From: Simon Davis
Sent: 09 April 2019 12:46
To: Planning.Responses
Subject: FW: BN/50/18/PL - SW Drainage
Attachments: Drawing 23B - SW Drainage Plan.pdf; Permavoid Standard Detail.pdf; Micro Drainage Calcs March 2019.pdf; Re: BN/50/18/PL The Fallows

From: stephen jupp <[REDACTED]>
Sent: 08 April 2019 15:17
To: Simon Davis <[REDACTED]> Laura Gibbons <[REDACTED]>
Cc: Danny Keet <[REDACTED]>
Subject: BN/50/18 - SW Drainage

Drawing 23B – SW Drainage Plan
Scale 1:200 @ A3

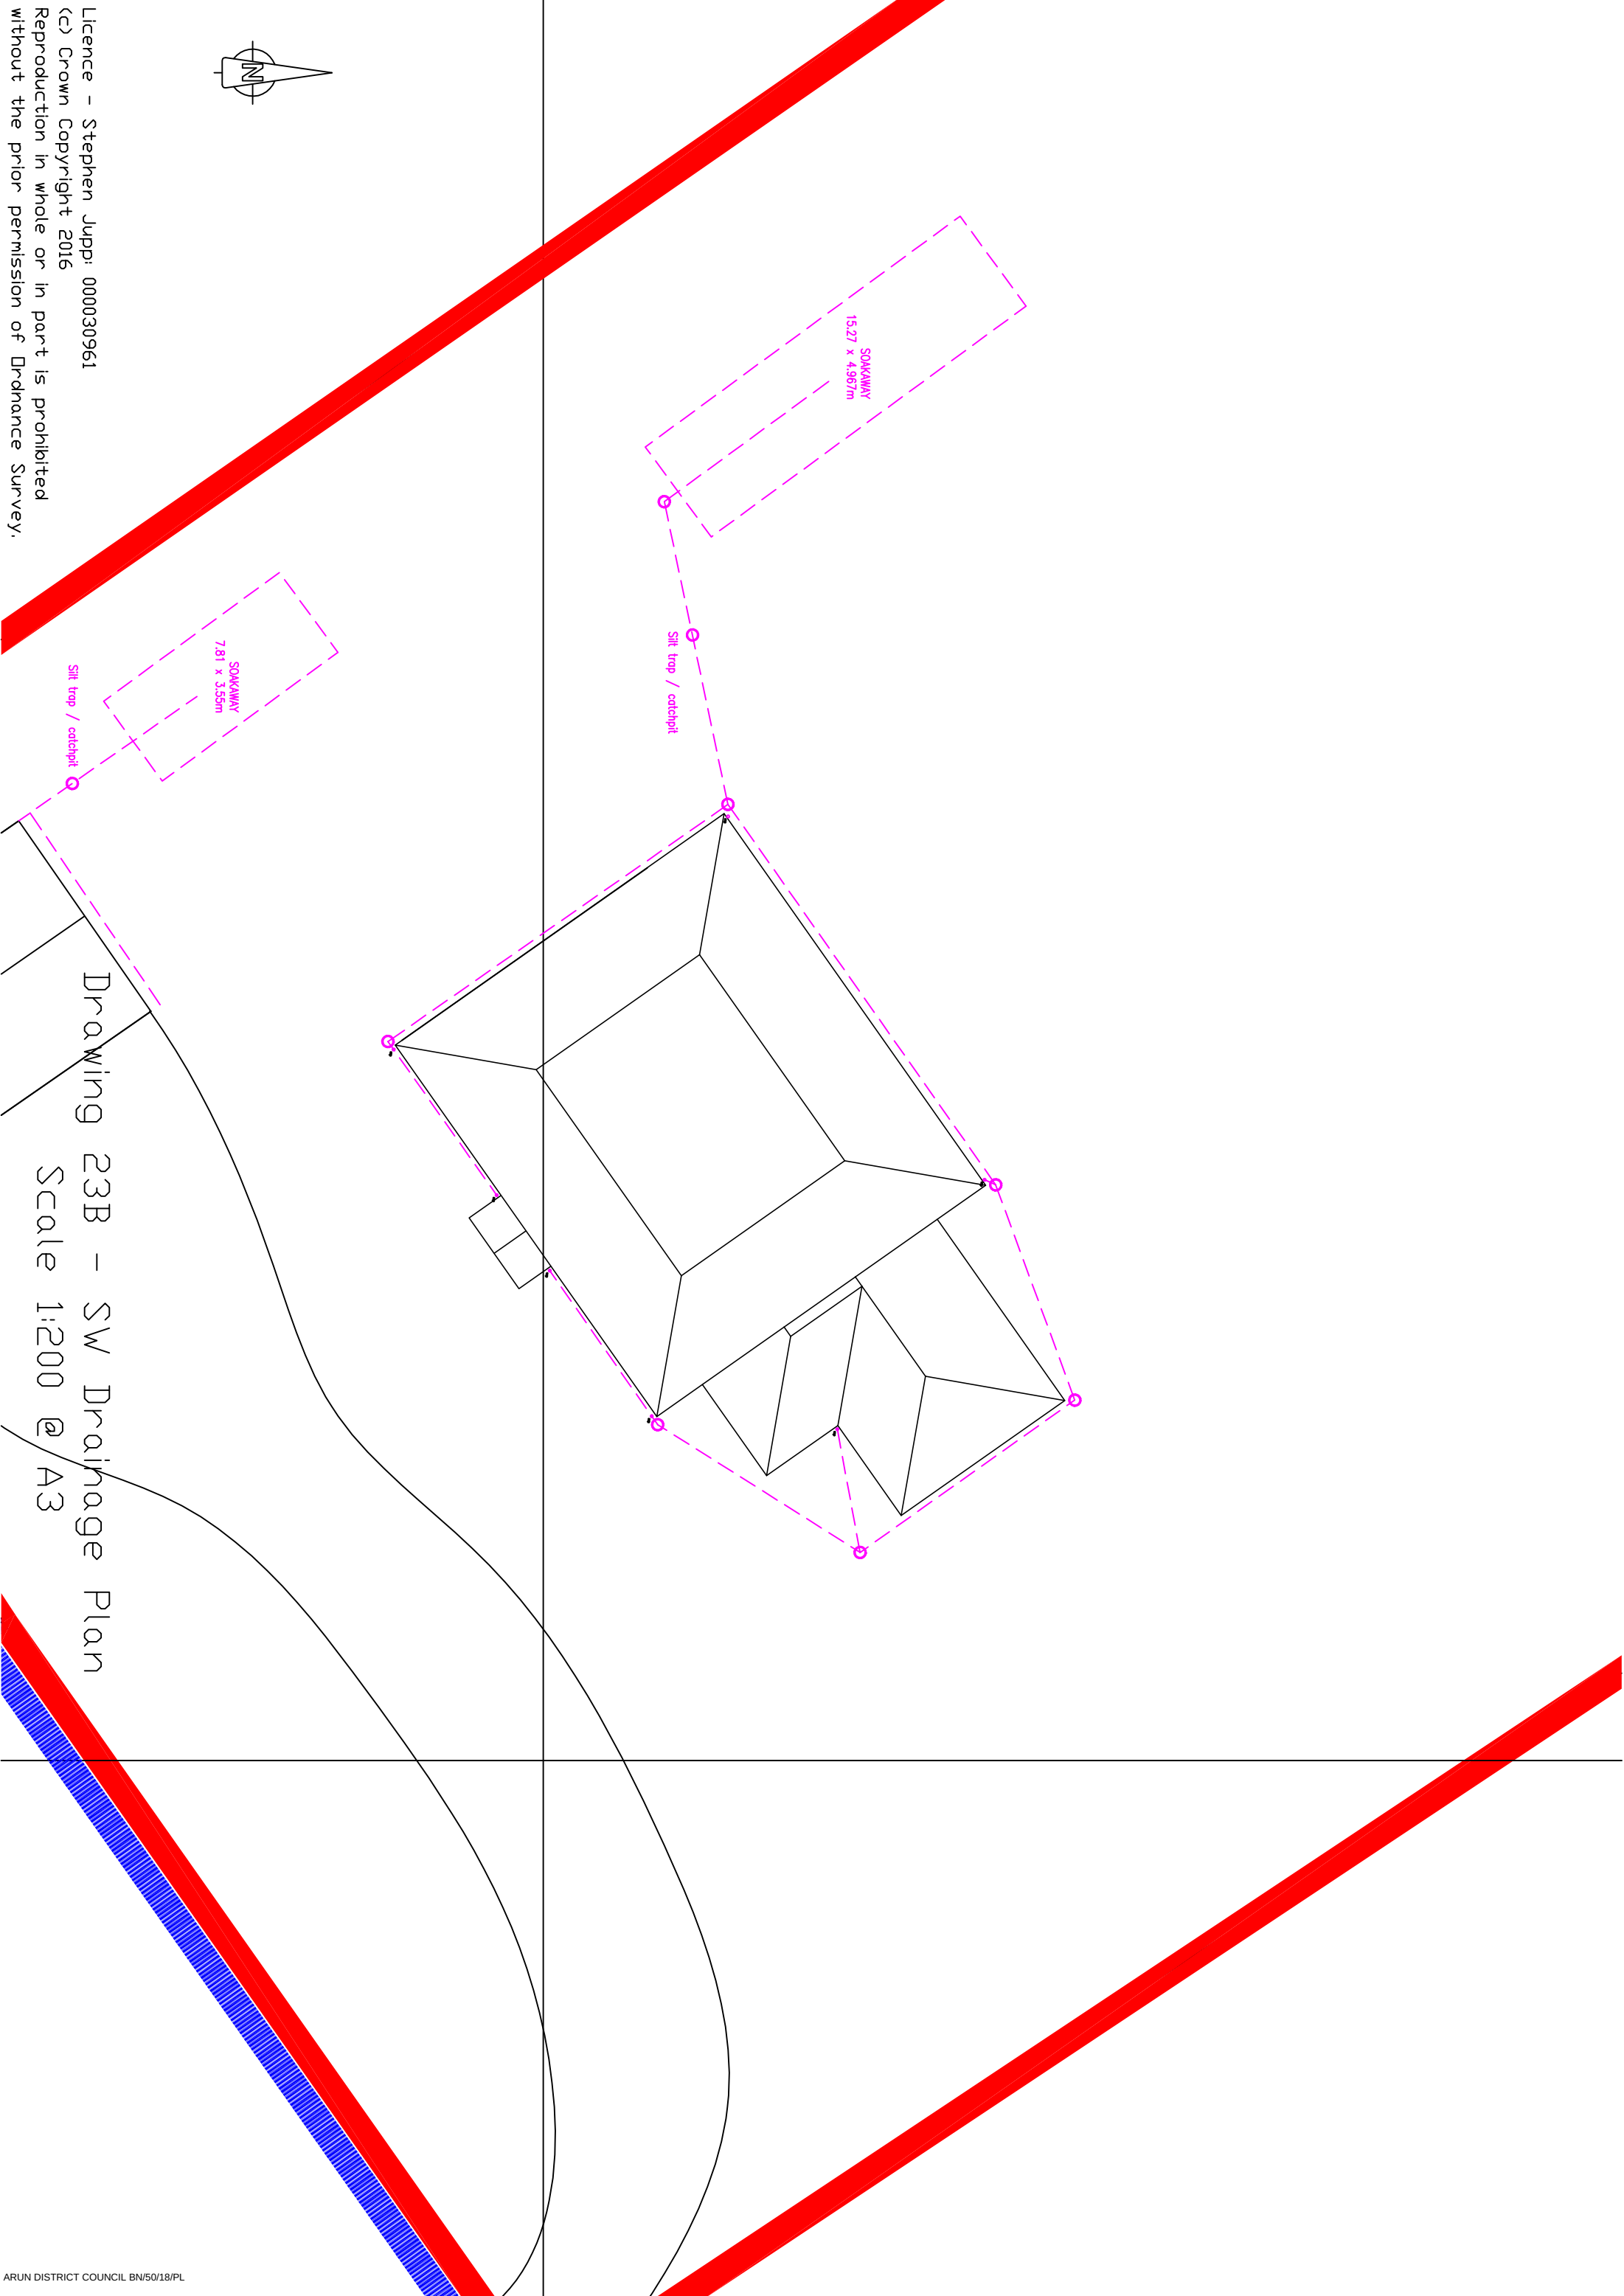
I have just seen Laura's comments and attached an amended plan to clarify the soakaways. The previous drawing showed the location of the silt traps and these are repeated. Levels are not feasible at this pre-permission stage so i ask that the following matters are subject to a pre-commencement condition:

- invert and cover levels although this would be covered by b regs

As to pipe details, again this is a b regs matter but they would be 100mm dia [non-perforated] plastic pipes, laid to 1:100 falls in a granular material, max 10mm size.
